**Subject:** FW: 2021/92904 - Yangtze Chinese Restaurant, Park View, 149 Halifax Road, Liversedge, Dewsbury, WF15 6NU  
**Date:** 15 October 2021 12:37:58

**Subject:** RE: 2021/92904 - Yangtze Chinese Restaurant, Park View, 149 Halifax Road, Liversedge, Dewsbury, WF15 6NU

DRAWING TITLE
EXISTING SITE PLAN
CLIENT

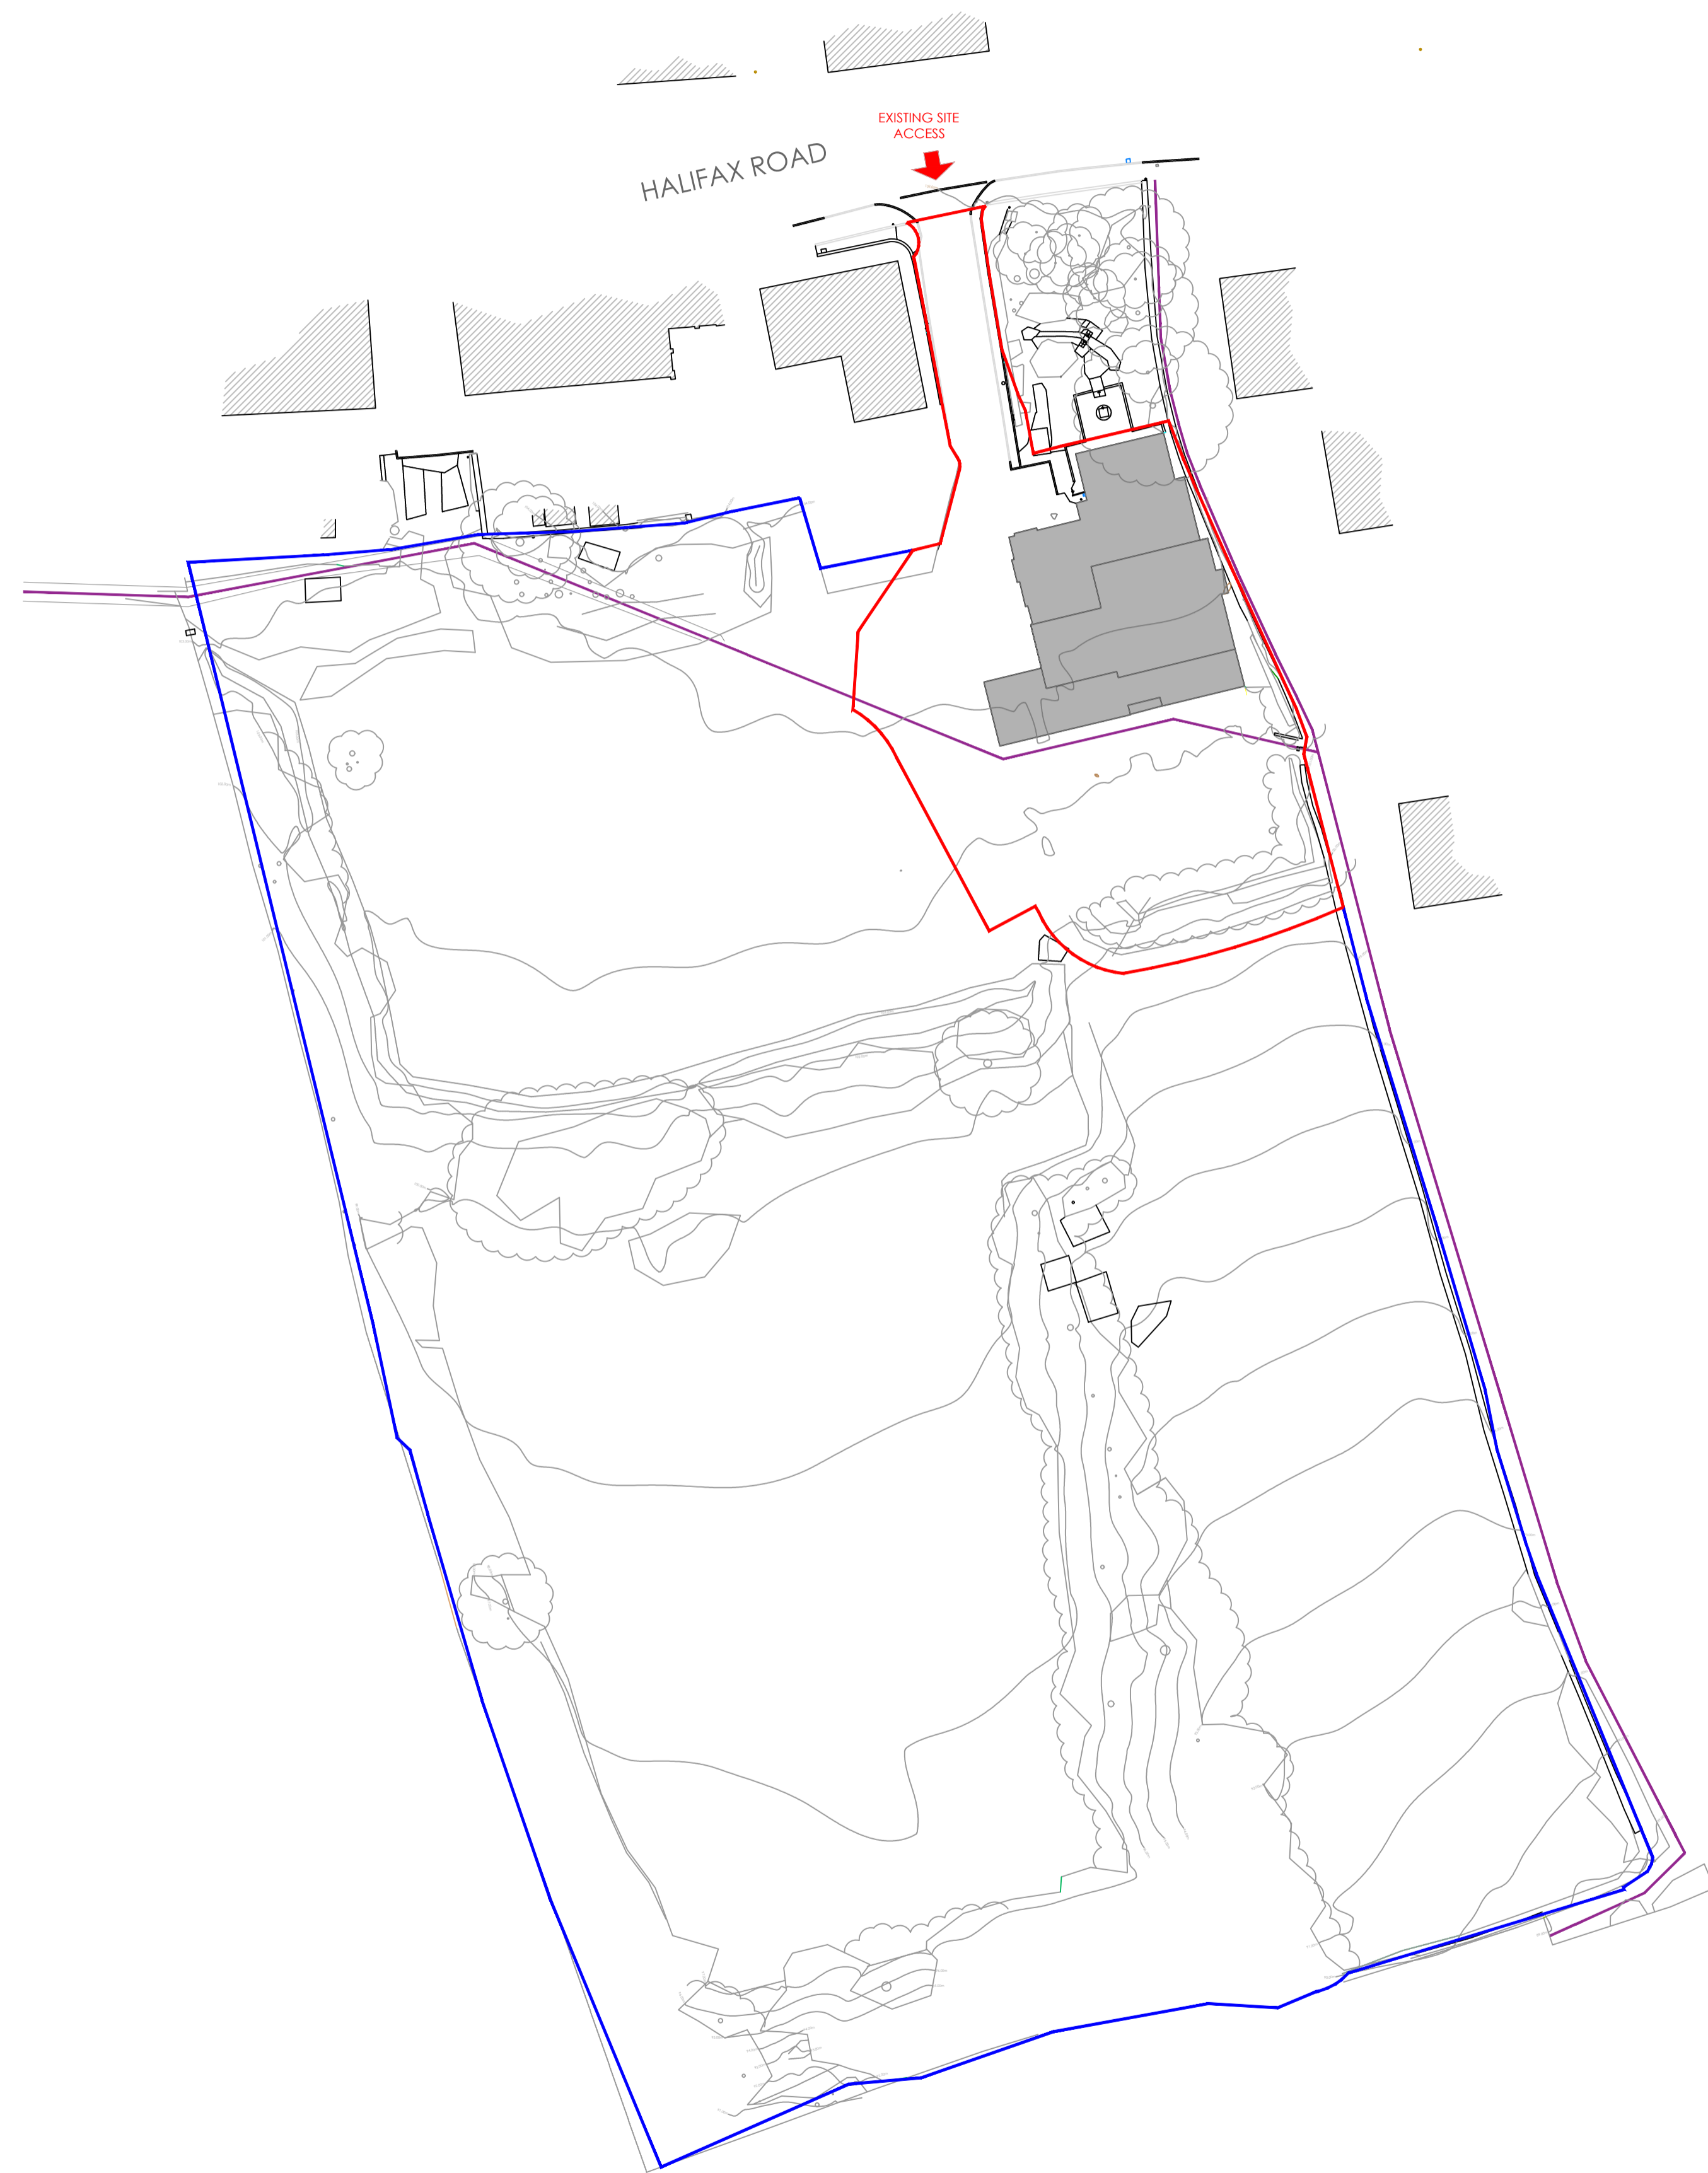
In this instance, highway officers would stipulate that a 9.5m highway (5.5m carriageway and 2x2.0m footways) can be achieved with a minimum junction radius of 6.0m. It would seem that this cannot be accommodated whilst the restaurant building is retained and HDM would therefore ask that this is demonstrated on a plan to ensure a workable scheme can be provided.
